Please ask for: Nicola Moore
Email: nicola.moore@arun.gov.uk
Telephone: Ext 37944
Our Ref: P/10/21/HH
Your Ref:
Date: 27th January 2021

Application for Planning Permission for Works or Extension to a Dwelling

Development: Replacement garden structure to provide a hobbies/fitness room
Location: 4 Canterbury Close Pagham PO21 3QX

4, Canterbury Cl. Bognor Regis
PO21 3QX

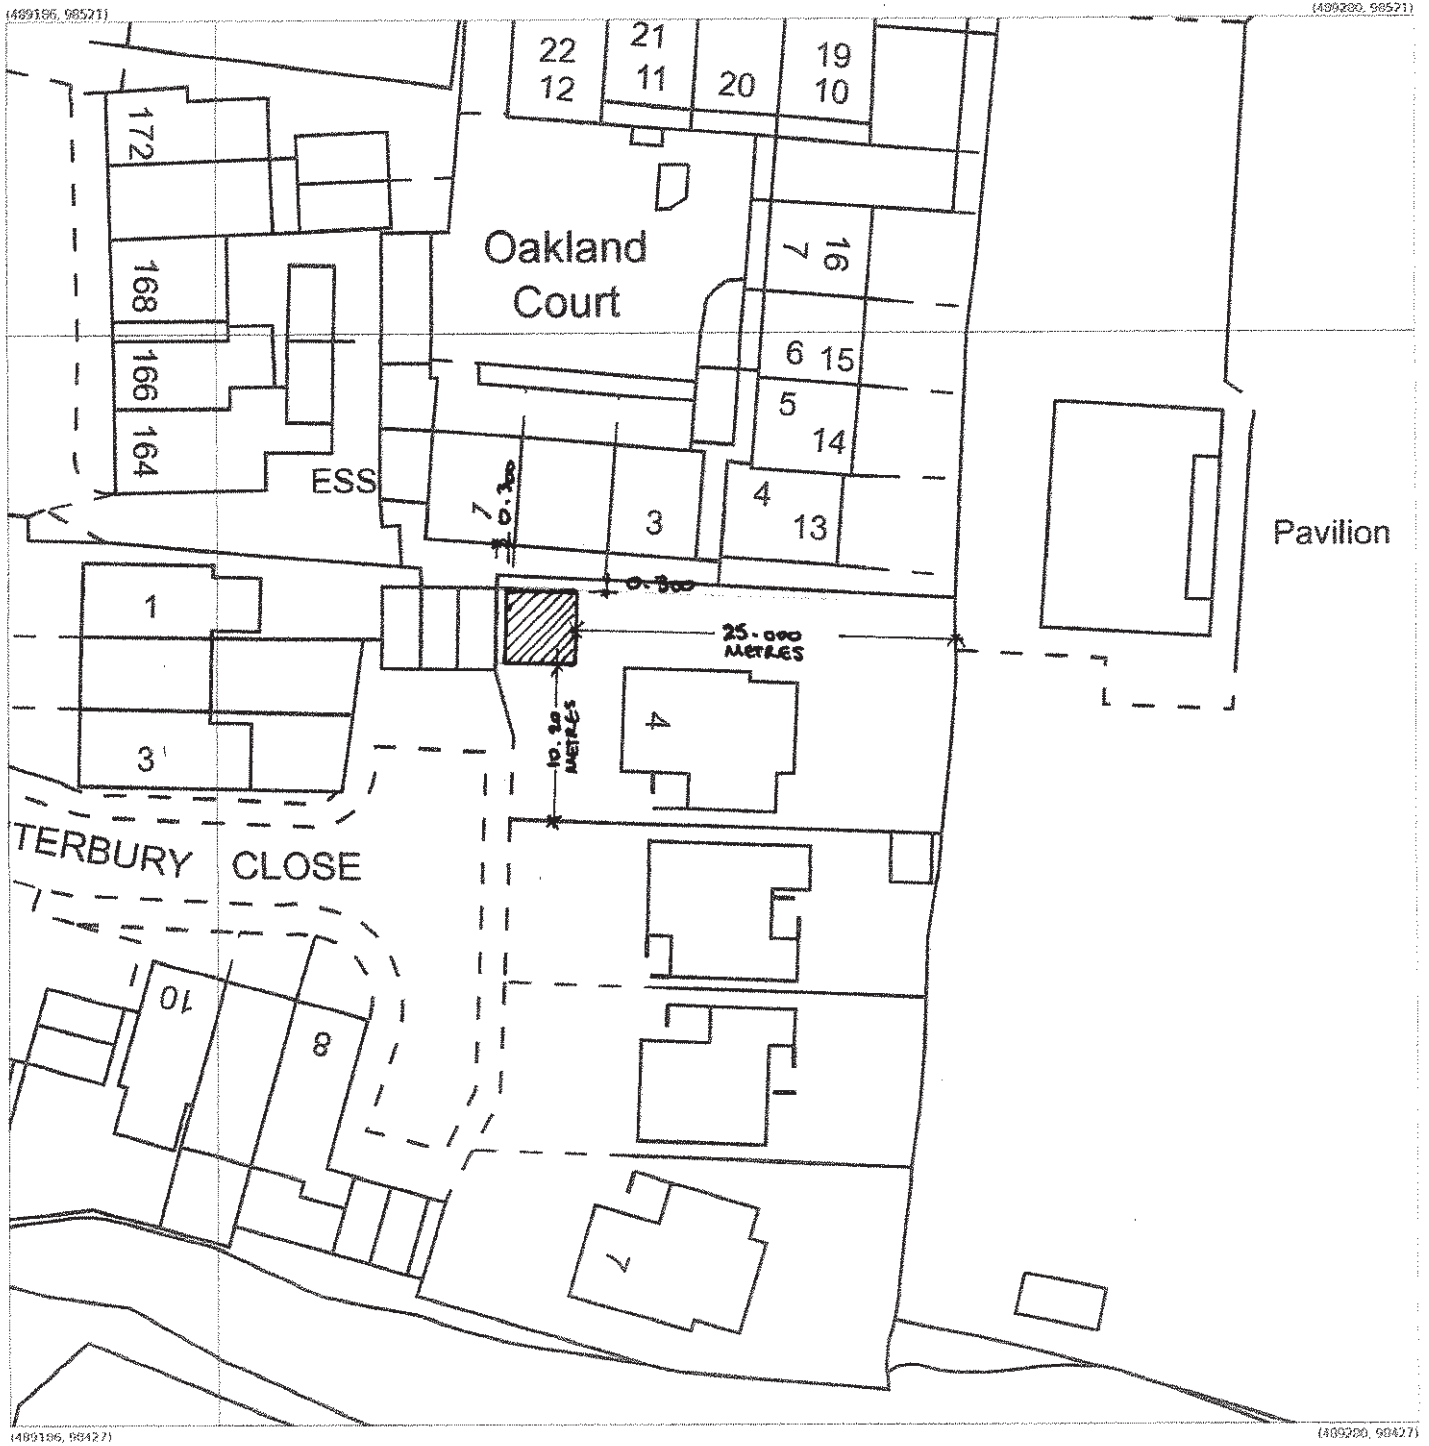
Block Plan

The Block plan should include written dimensions to boundaries from the proposed development. Please amend accordingly and re submit.
